Memorandum

To: Carmen Moran
CC: Nancy Cline, Aaron Russell
From: Clay Barnett
Date: 11/2/2007
Re: The Residences of Addison Circle

84 LOTS ~ 3.98 ACRES
PRELIMINARY PLAT
THE RESIDENCES OF
ADDISON CIRCLE

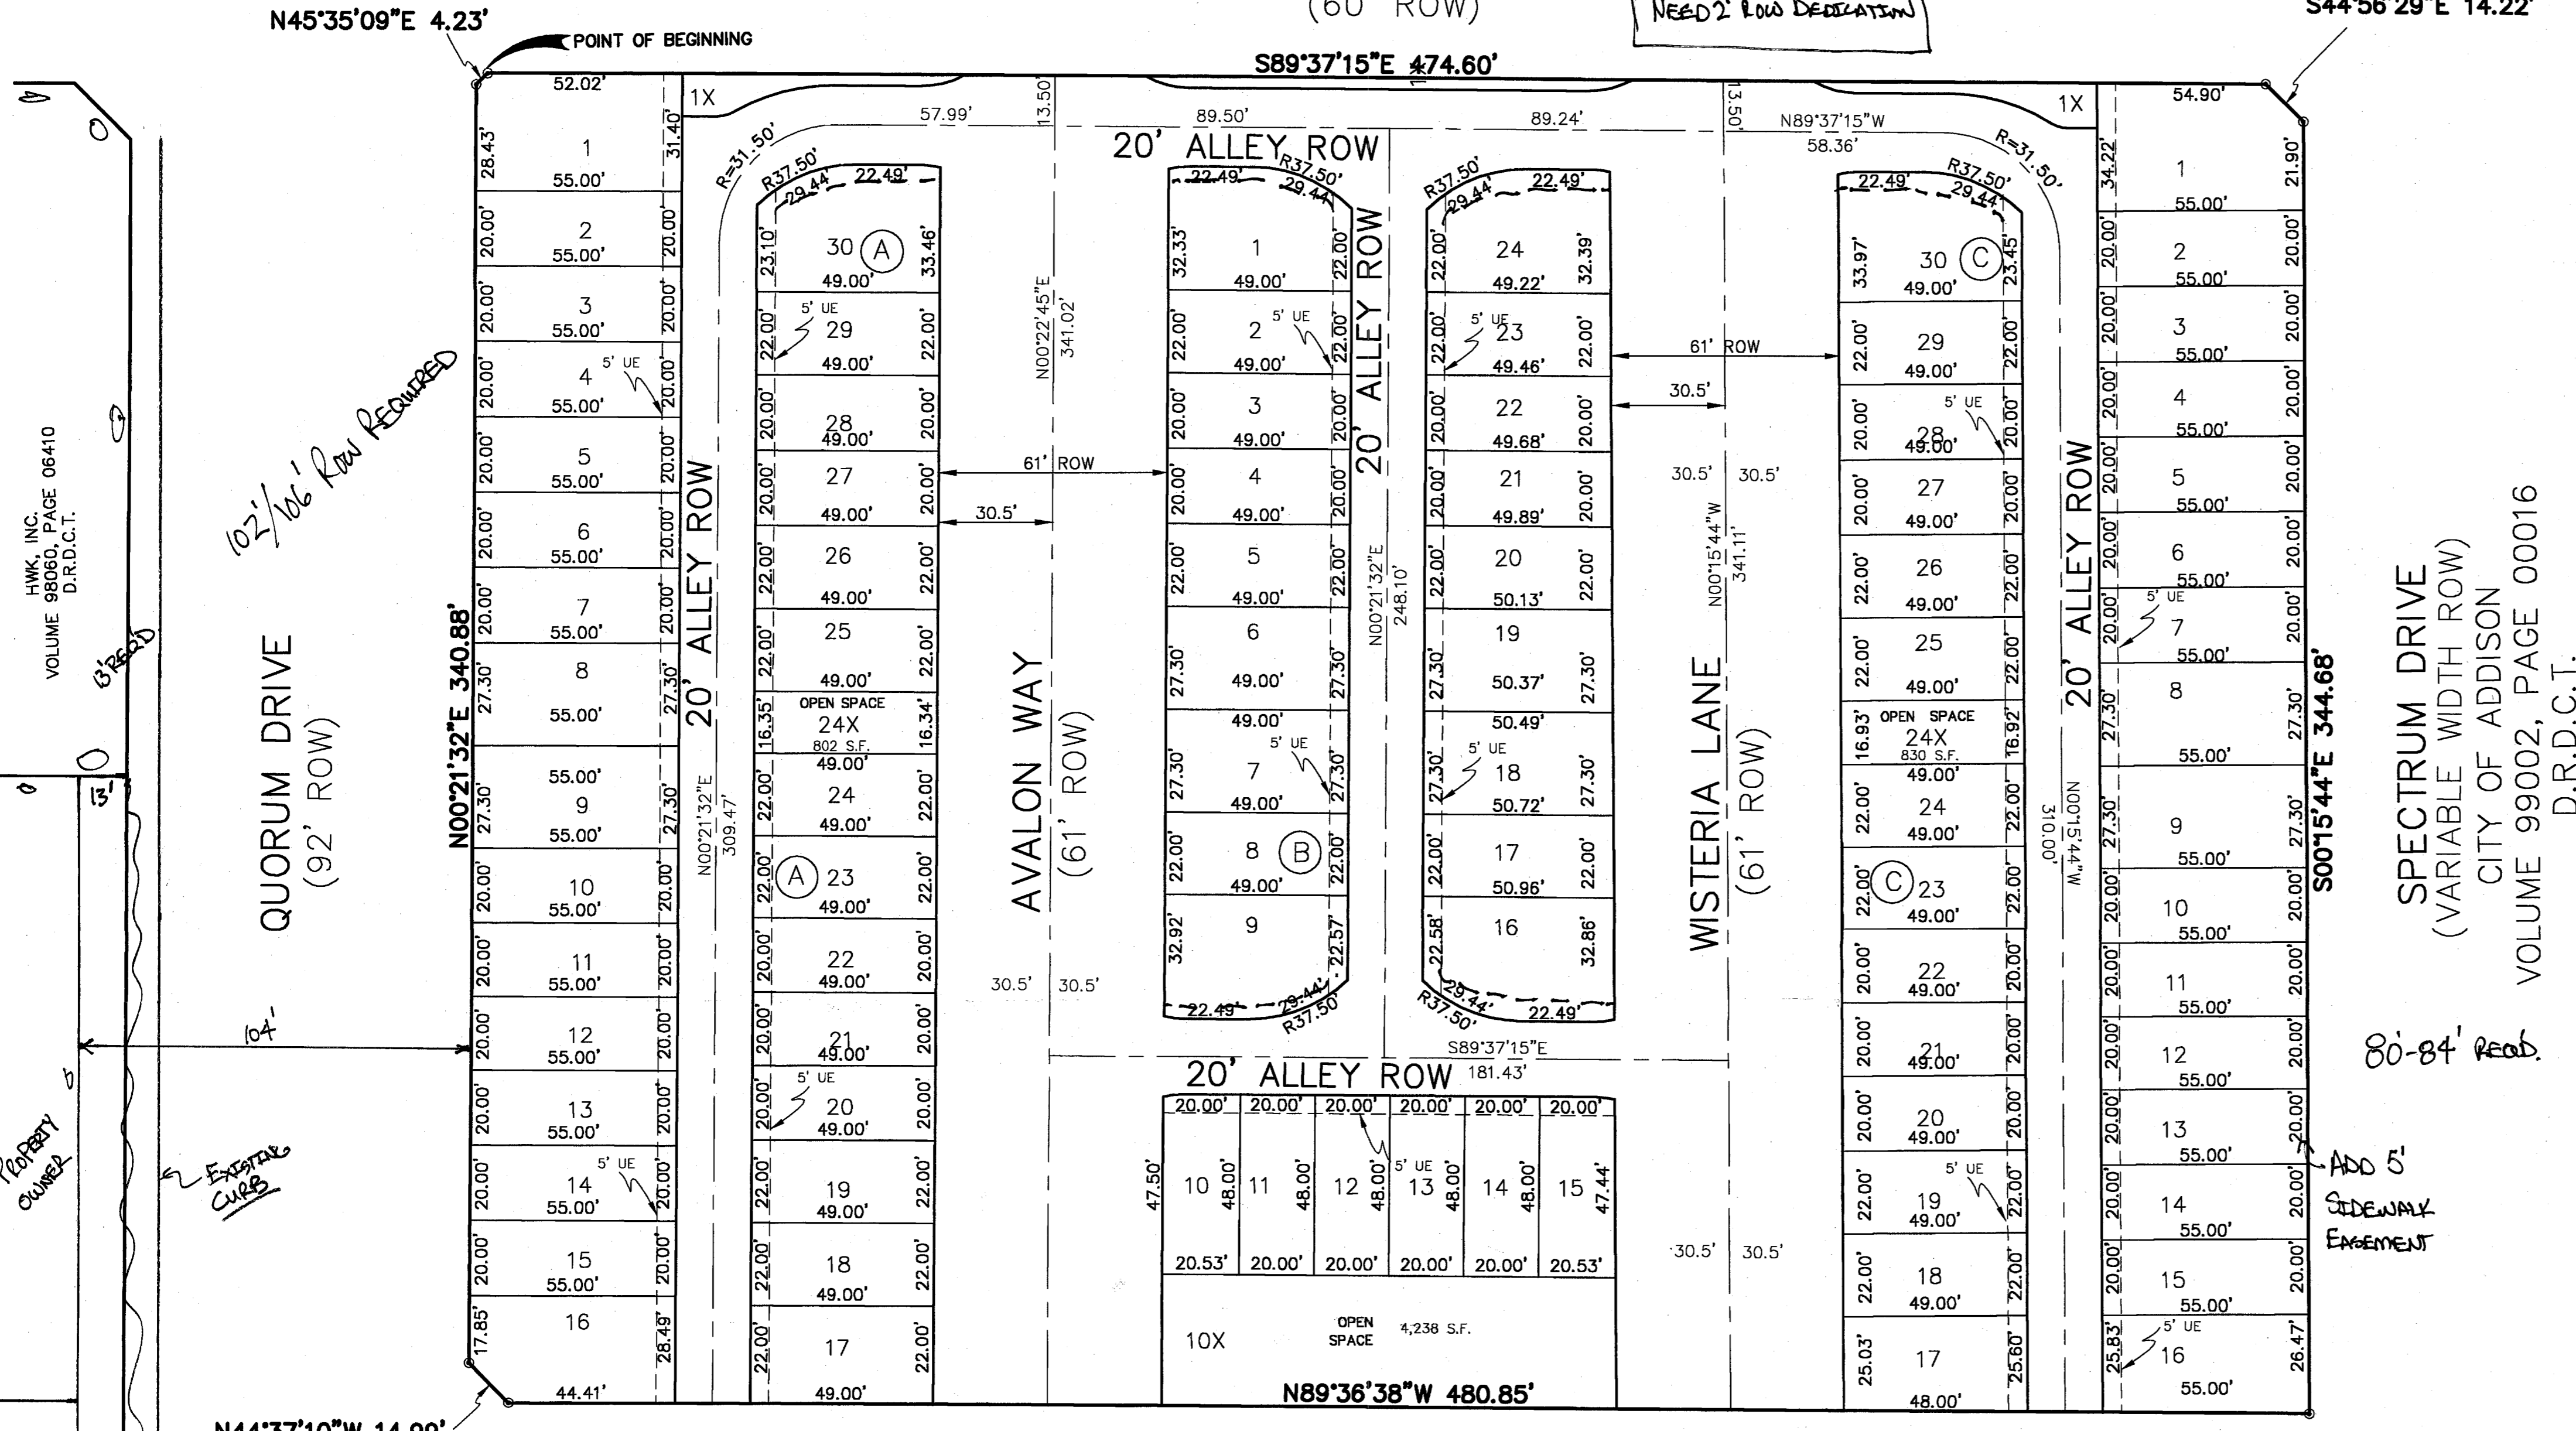
1. The Thoroughfare Plan designates Airport Parkway as a Commercial Collector which requires a 64' Right-of-Way. As a result, a 2' right-of-way dedication is required on the plat for Airport Parkway.

2. Change all references of "City of Addison" to "Town of Addison."
3. Add building setbacks in accordance with the amendment to the UC zoning. Add a reference to the amendment to the face of the plat.

4. Add center lines to existing streets.
5. Street names shall be chosen from the Town of Addison approved list. Please revise.
6. Add a 5' Sidewalk Easement along the Spectrum Drive frontage.

7. A reference to the Quorum Drive East Addition recorded in Volume 98001, Page 00033 needs to be added to the Owner's Certificate.
8. Place a 5' Utility Easement in the side yard along the frontage on Lot 30, Block A, Lots 1, 9, 16 & 24, Block B and Lot 30, Block C.

9. Show all lot lines, property owners and dimensions for the parcels across each public right-of-way.
